WEST SUSSEX COUNTY COUNCIL CONSULTATION

TO:	Arun District Council FAO: Maria Tomalova
FROM:	WSSC - Highways Authority
DATE:	24 June 2021
LOCATION:	Rear of 7 Middleton Road, Felpham, PO22 6BL
SUBJECT:	FP/124/21/PL Detached double garage. This site is in CIL Zone 4 (Zero Rated) as other development.
DATE OF SITE VISIT:	N/A
RECOMMENDATION:	Advice
S106 CONTRIBUTION TOTAL:	N/A

PL03 - Site & Location Plans

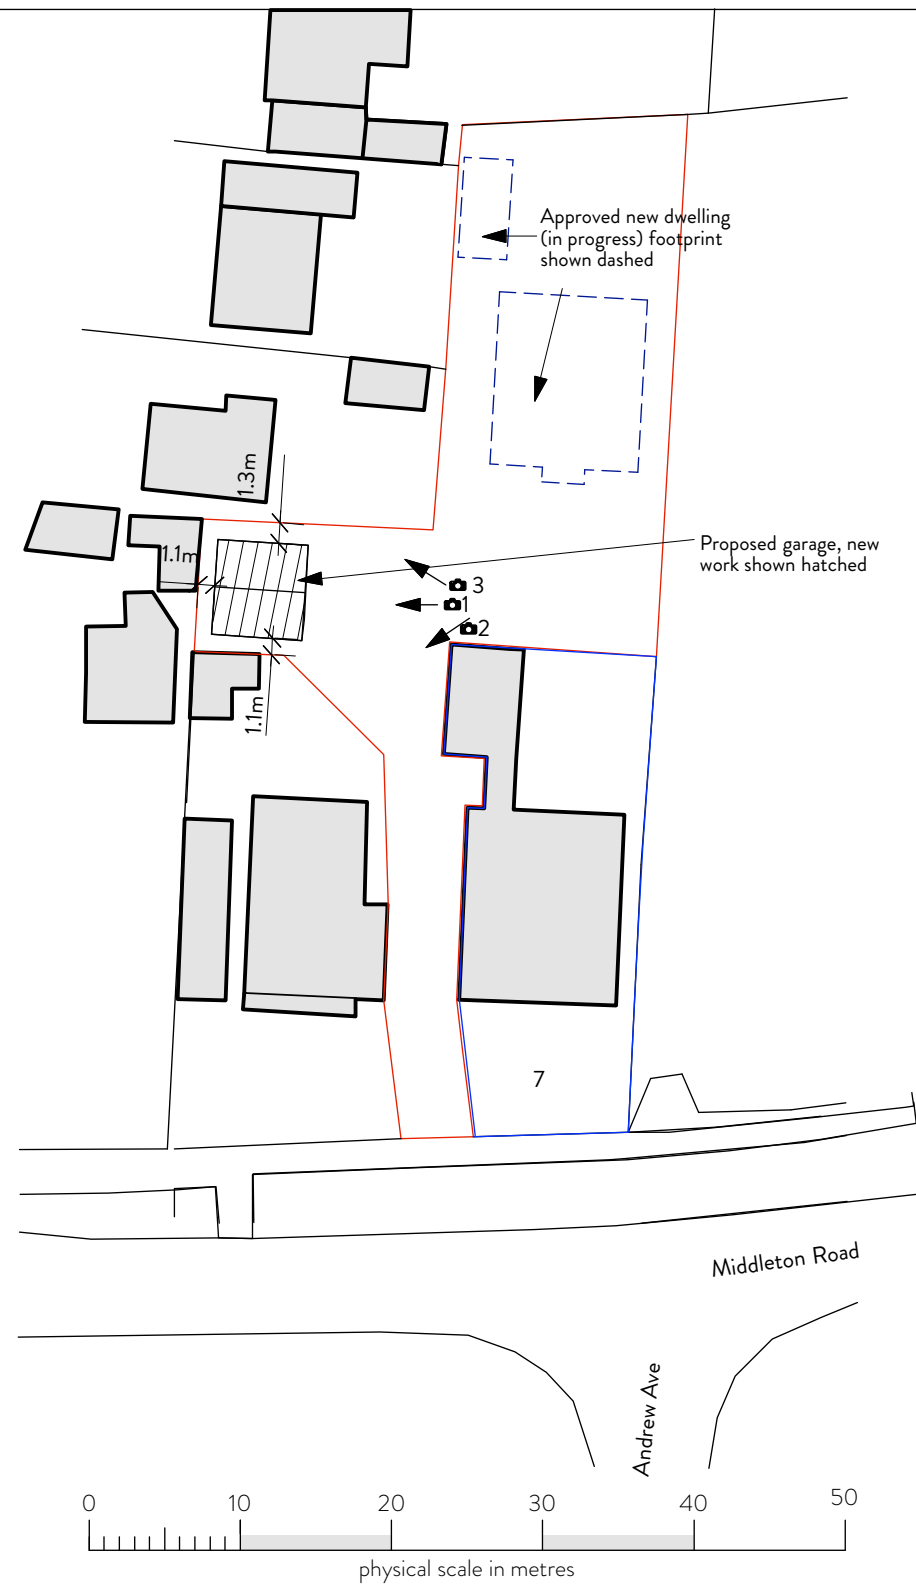
Notwithstanding the above, the LHA acknowledge that the proposed garage will provide additional parking for the proposed dwelling. From inspection of the plans, there is space for on-site turning to be achievable, allowing cars to exit the site in a forward gear.

PL01 - Proposed Garage

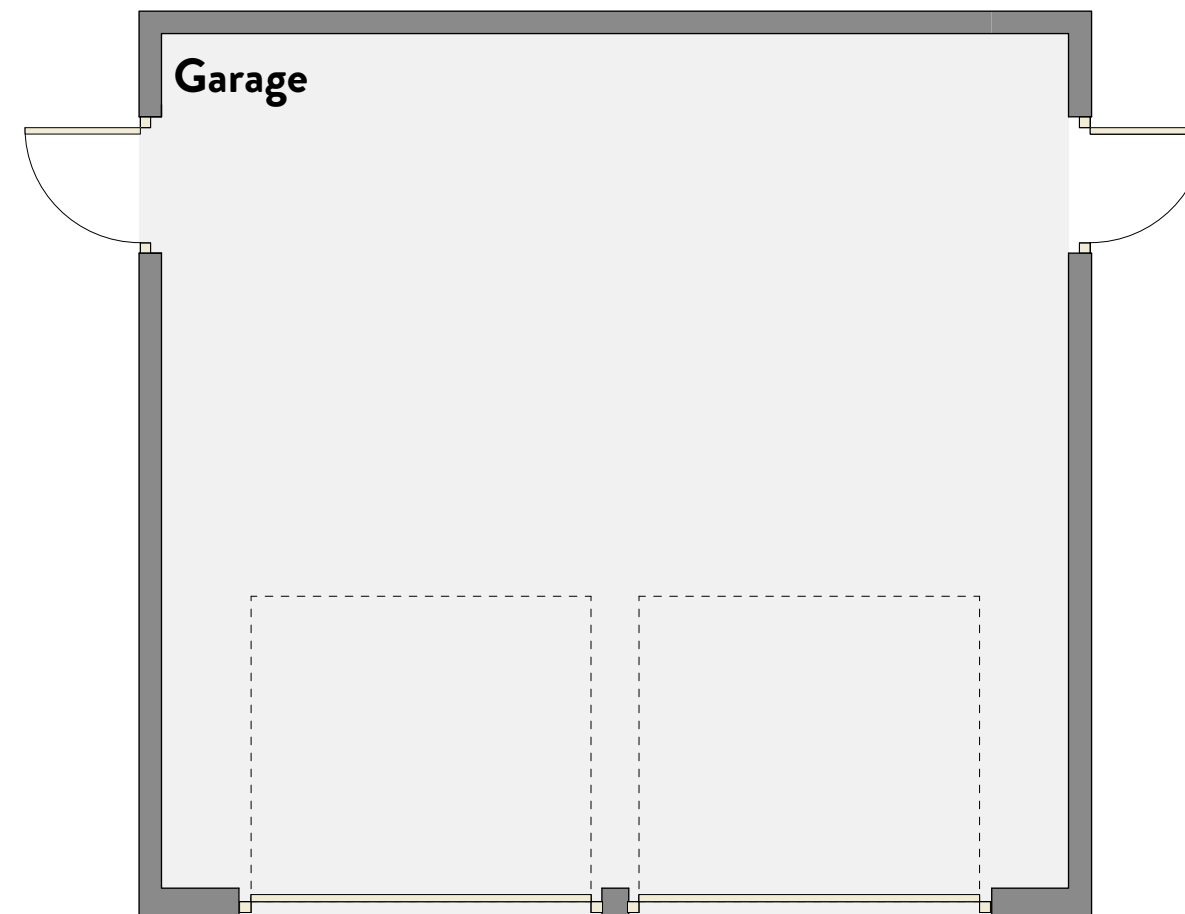
The applicant proposes a double-car garage, which will provide parking for a dwelling approved under application FP/203/17/PL. From inspection of the plans, the proposed garage will have approximate internal dimensions of 6m x 5.6m. This falls slightly short of the minimum internal specifications for double-car garages of 6m x 6m as set out in Manual for Streets (MfS). Therefore, the LHA cannot consider the garage for parking provision and advises the applicant to enlarge the garage to 6m x 6m.

In conclusion, the LHA does not consider that this proposal would have an unacceptable impact on highway safety or result in 'severe' cumulative impacts on the operation of the highway network, therefore is not contrary to the National Planning Policy Framework (paragraph 109), and that there are no transport grounds to resist the proposal. However, the applicant is advised to enlarge the proposed garage to meet MfS specifications for double-car garages of 6m x 6m.
